Planning Reference: Y/32/25PL Redrow Homes Ltd. Planning Application for 170 dwellings for Land West of Bisham Rd. BN18 0LA

**Further Objections to the Redrow Application (2) Y32/25/PL,
Drainage and Flooding**

May26th 2025

Drawing Title  
**PROPOSED SURFACE WATER DRAINAGE LAYOUT, SHEET 7 OF 8**

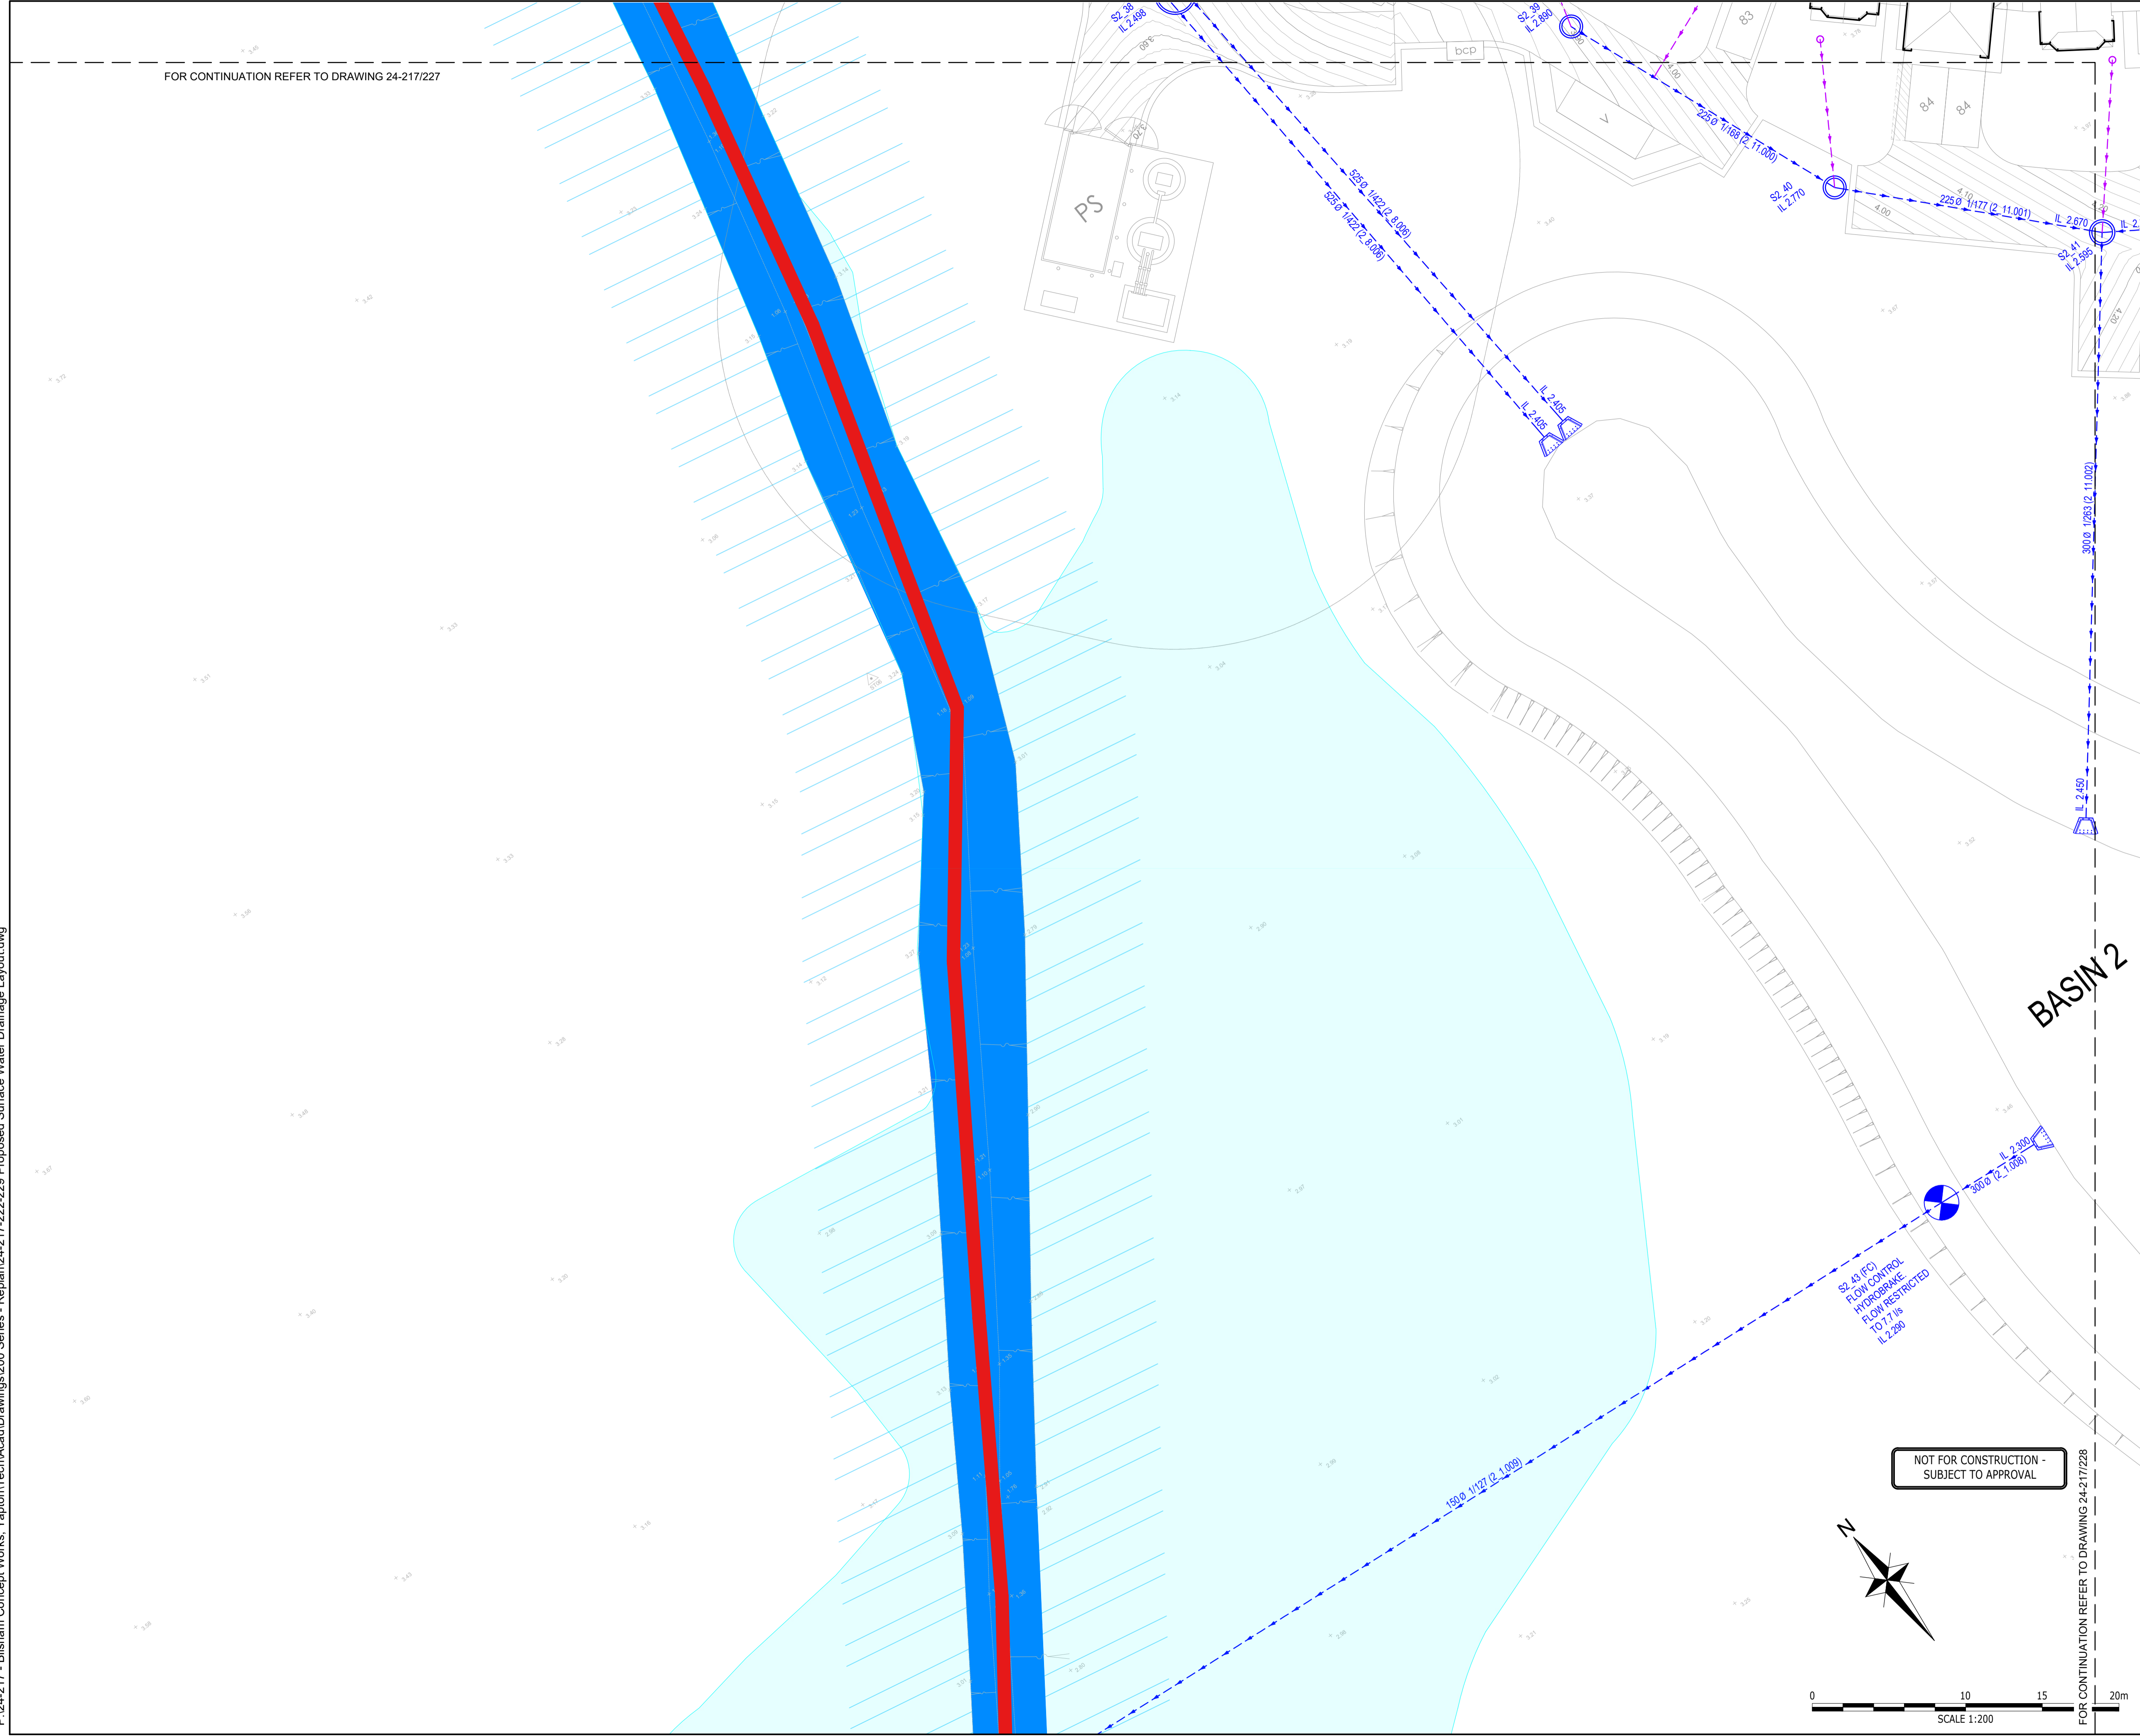
(2) The 'DE' also indicated that the green field run-off had only been assessed for a drained area as approx. a third of the site, not the whole.

(4) Also stated; *'That the base of the attenuated basin and cellular tank is located **below** the top of the level of the adjacent watercourse. There is a potential for the watercourse to back up into the basin. Please demonstrate how this will be done'* No satisfactory explanation was allegedly given by Odyssey in response.

(5) Also stated: *'The base of basin S is located below the predicated flood level. Please demonstrate that the basin will remain effective during a flood event'.*

(6) The former also stated '*Groundwater is noted as high. This could result in hydrostatic uplift of the liners that are to be installed to protect them from the ingress of groundwater.*'

They also caution that it may not be possible to excavate to necessary depth to install liners and ballast without adversely affecting other local water factors. They request hydrostatic uplift calculations for SUDS (basins and tank) and countering measures.

(7) The 'DE' report also refers that the freeboard is 300mm, (approx. a foot), has been provided as required by ADC, but that the DCG requirements are more extensive. Odyssey advised that the basins are to be in private maintenance. However, as no RP has been designated to purchase affordable housing to the site, or any other form of 'management' to take it over, and no s106 yet presented by Redrow Homes Ltd., that outcome cannot be confirmed.

(8) The 'DE' report advised of the plans details, indicating overflow routes concerns, over-topping of the basins and requested to know

As already confirmed by the 'DE', that the Rife, (watercourse) had already been identified as being higher than the basins, not 'falling to the West', the Odyssey response is allegedly at odds with the statements by the 'DE'.

MODELLED WATERCOURSE WATER LEVEL  
 1 IN 30YR - 2.558 mAOD  
 1 IN 100YR - CC - 3.091 mAOD

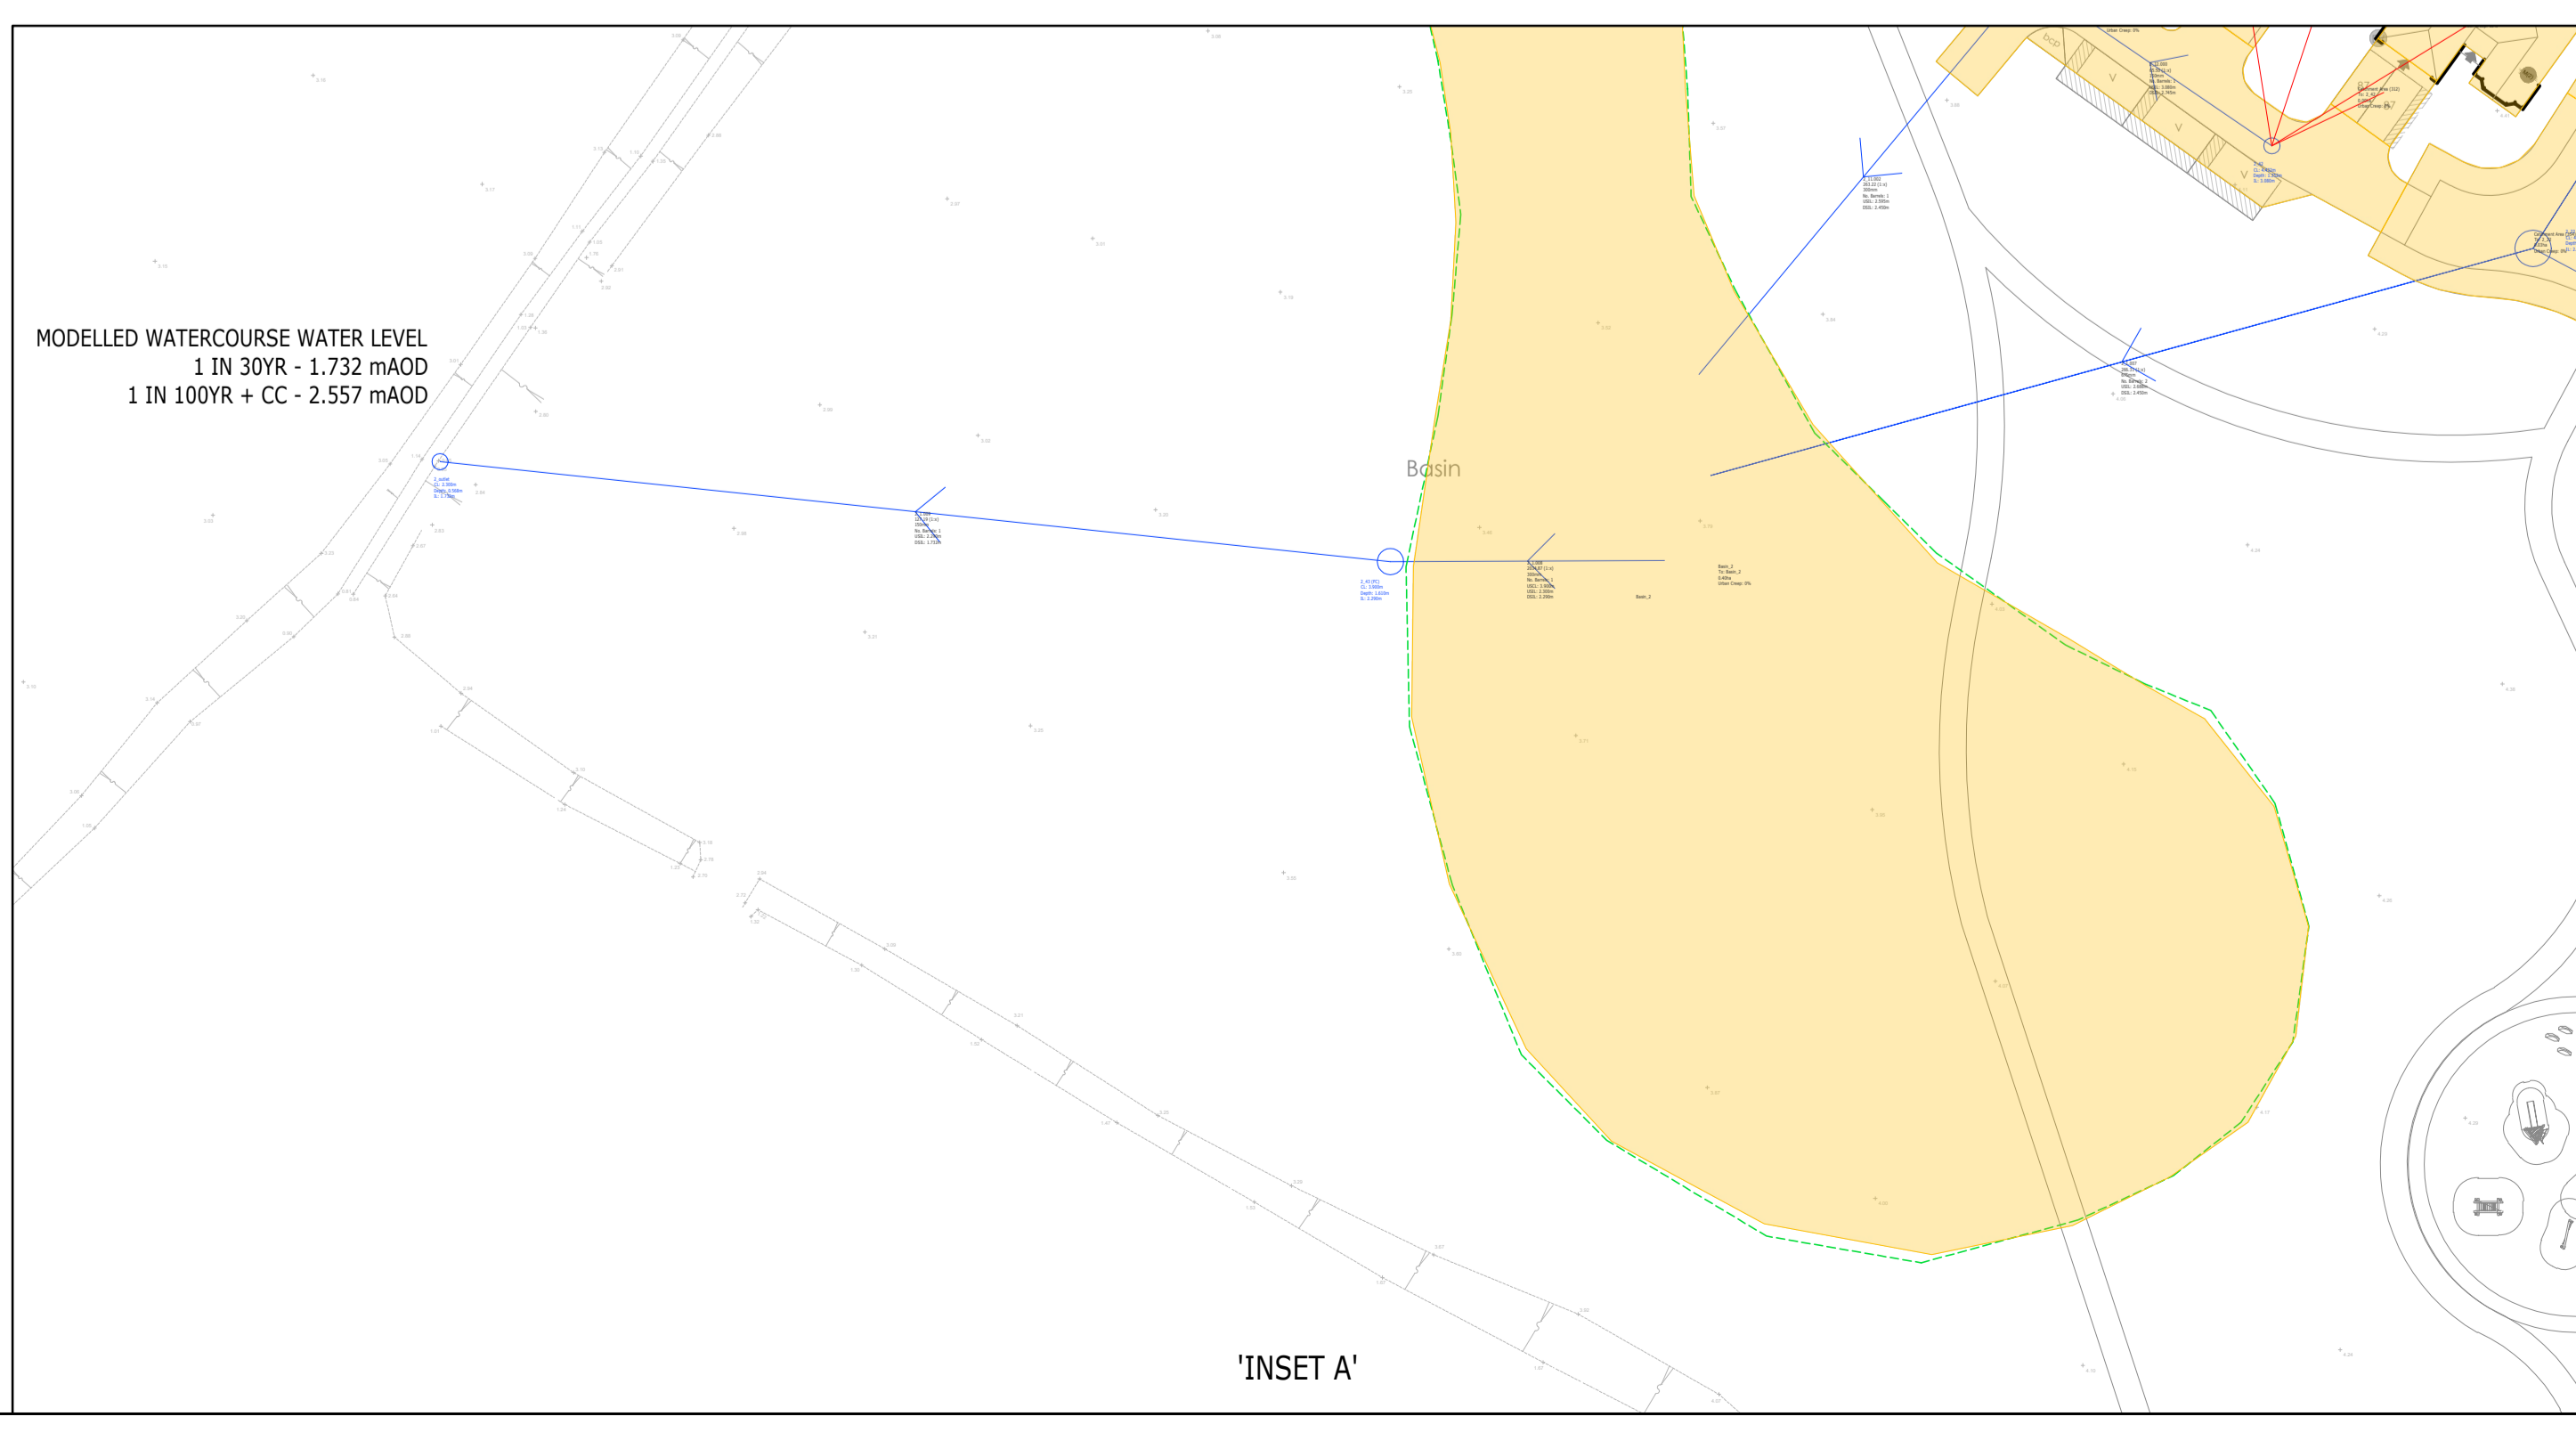
They also refer to *modelled* flooding possibilities in the area, not allegedly acknowledging the reason for the response request, was the raised level of the Rife to the rest of the site, and that the Rife

regularly overflows its banks into the Lamb's Field annually, not 1 in 5/10.
